**Howerton Services, PLLC**  
**License # P-1716**  
3513 Cathedral Bell Road  
Raleigh, NC 27614  
(919) 270-3460

Subject: Mason Residence  
206 Dauphine Street  
Fuquay Varina, NC 27526  
Pier Footing Inspection  
Harnett County Permit #: SFD2111-0088

FOUNDATION PLAN

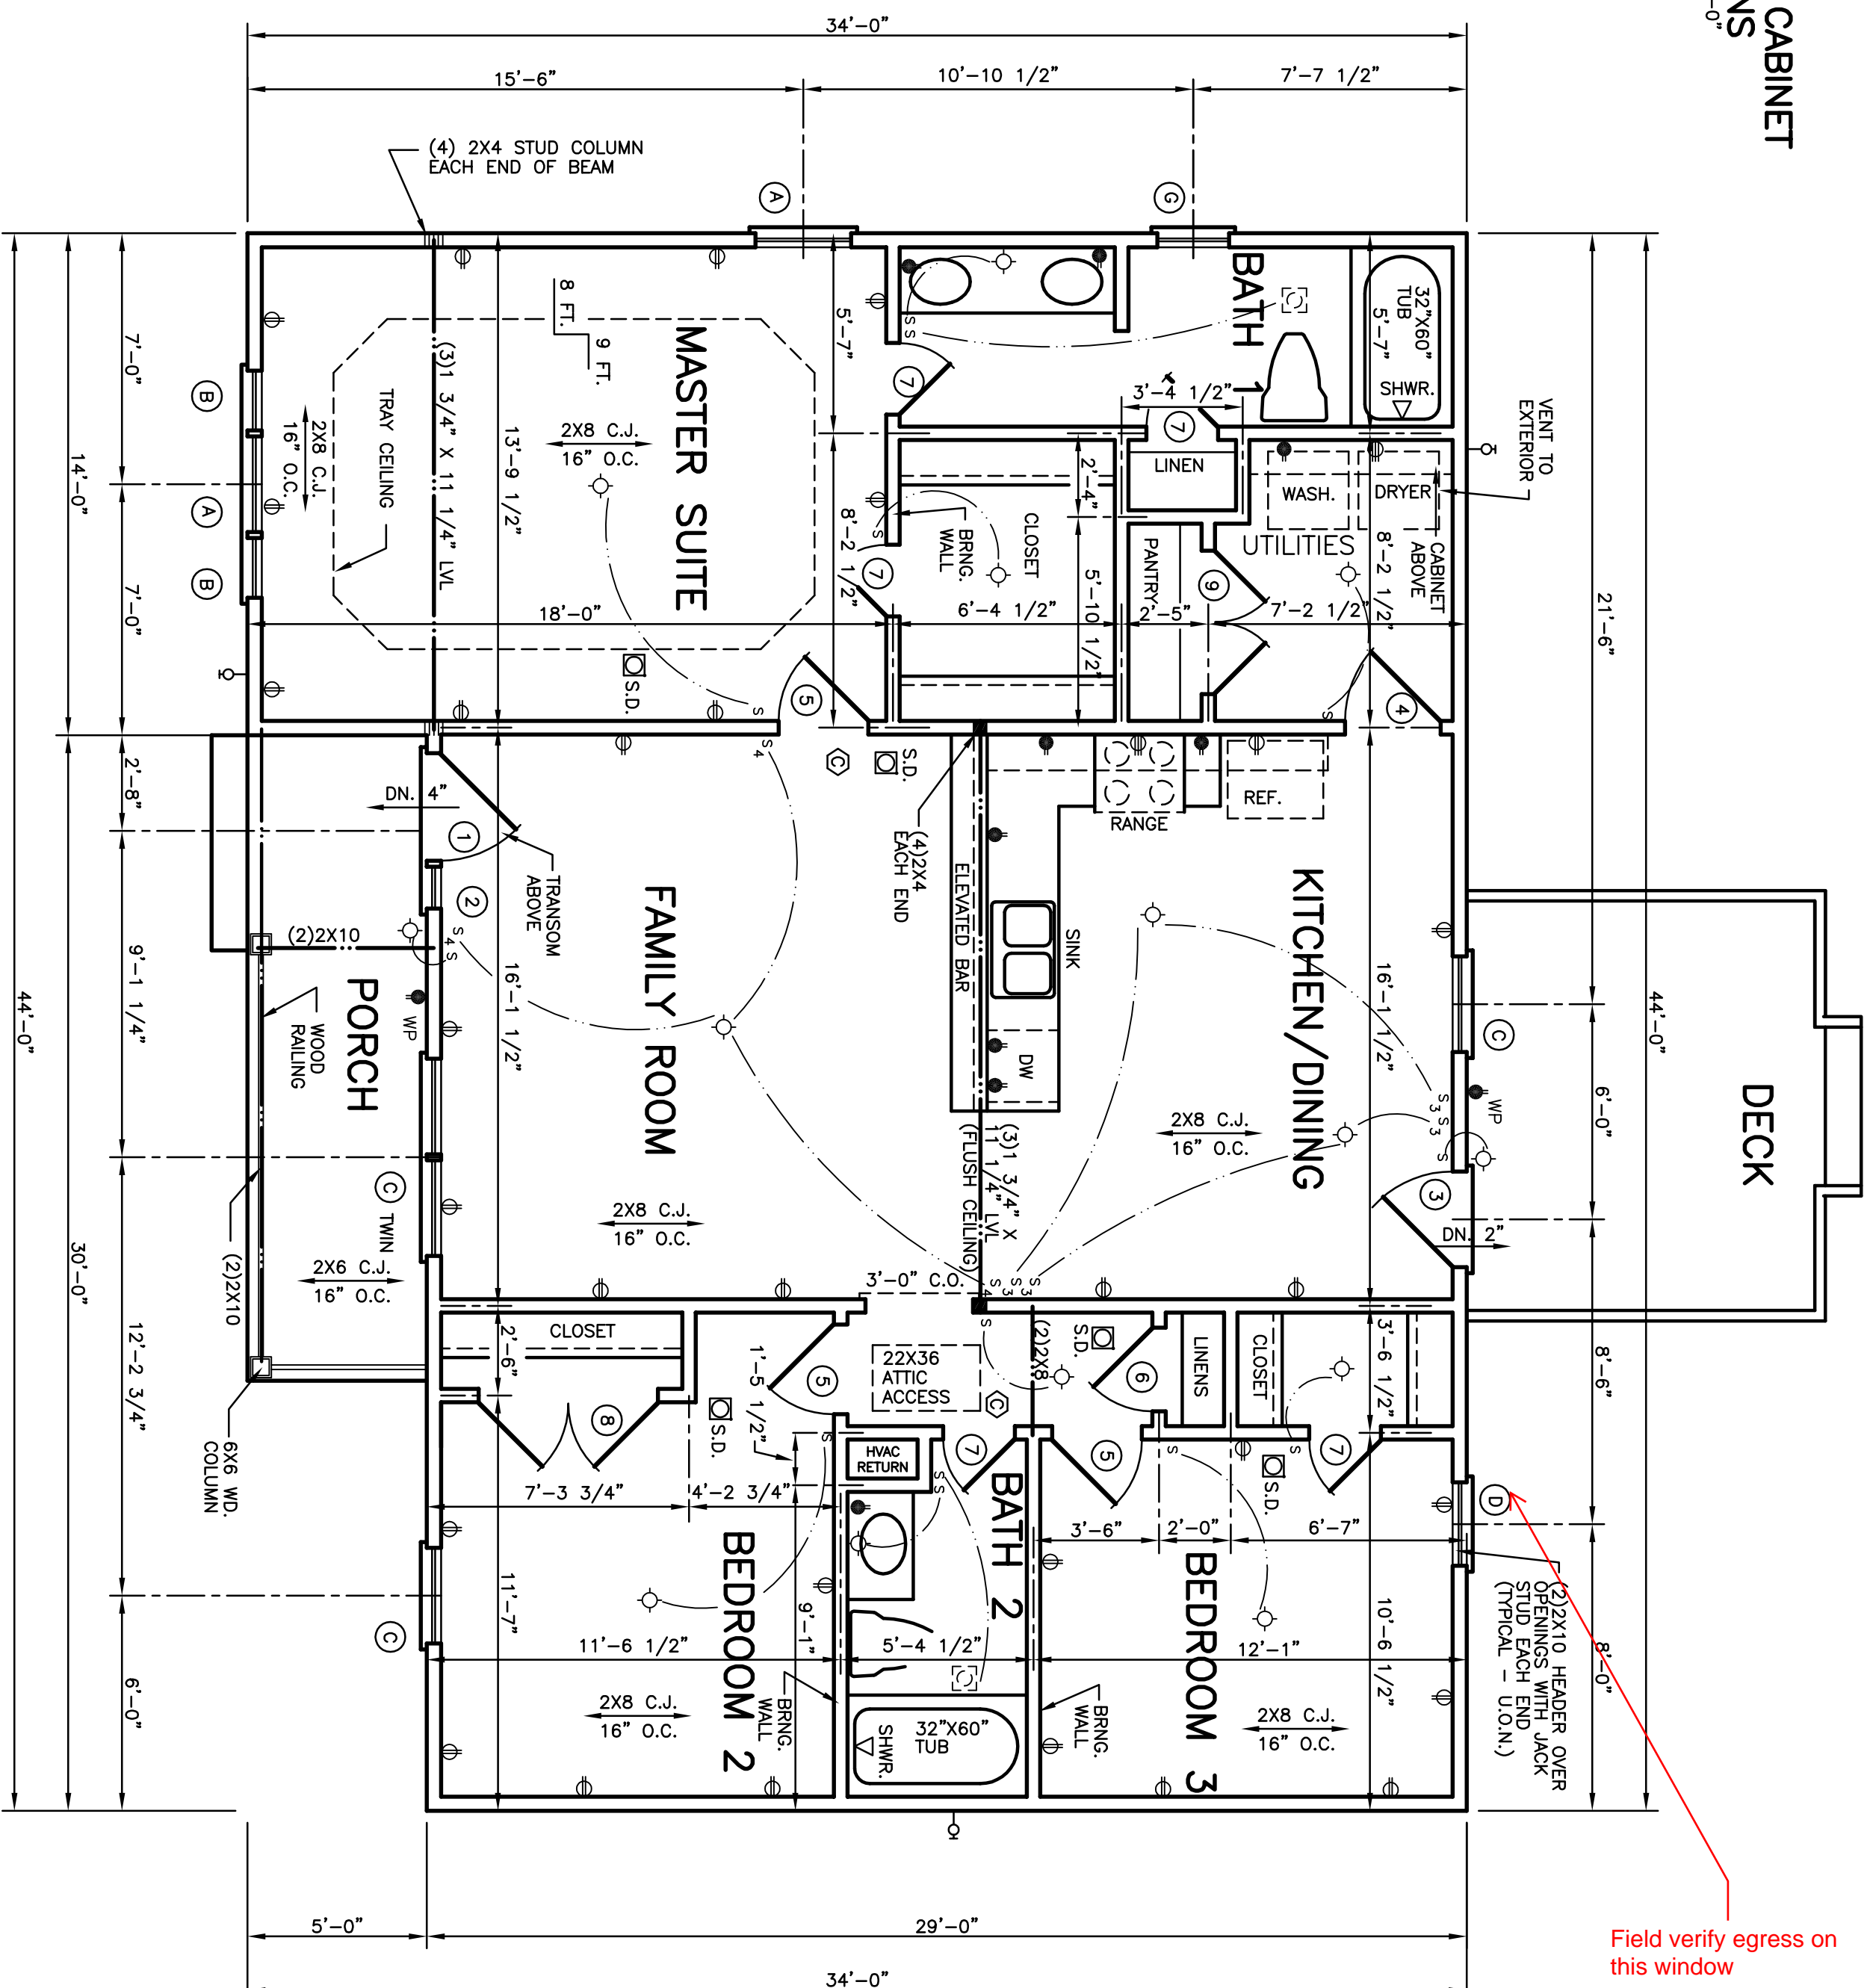
- The footings for 2 masonry piers on the left side of the crawlspace were not excavated in the correct location. Once the masonry piers were constructed on the concrete footings, the erected piers were too close to the edge on one side of the footings (didn't have the required 4" projection around all 4 sides of the piers). The contractor extended the footings 8" on 1 side of each pier to get the required projection. He added 3 - #4 dowel bars to the existing concrete footing to tie the existing footing to the new footing and poured the concrete into the extended side of the footings.

The extended pier footings meet all the requirements of the 2018 North Carolina Building Code for Residences.
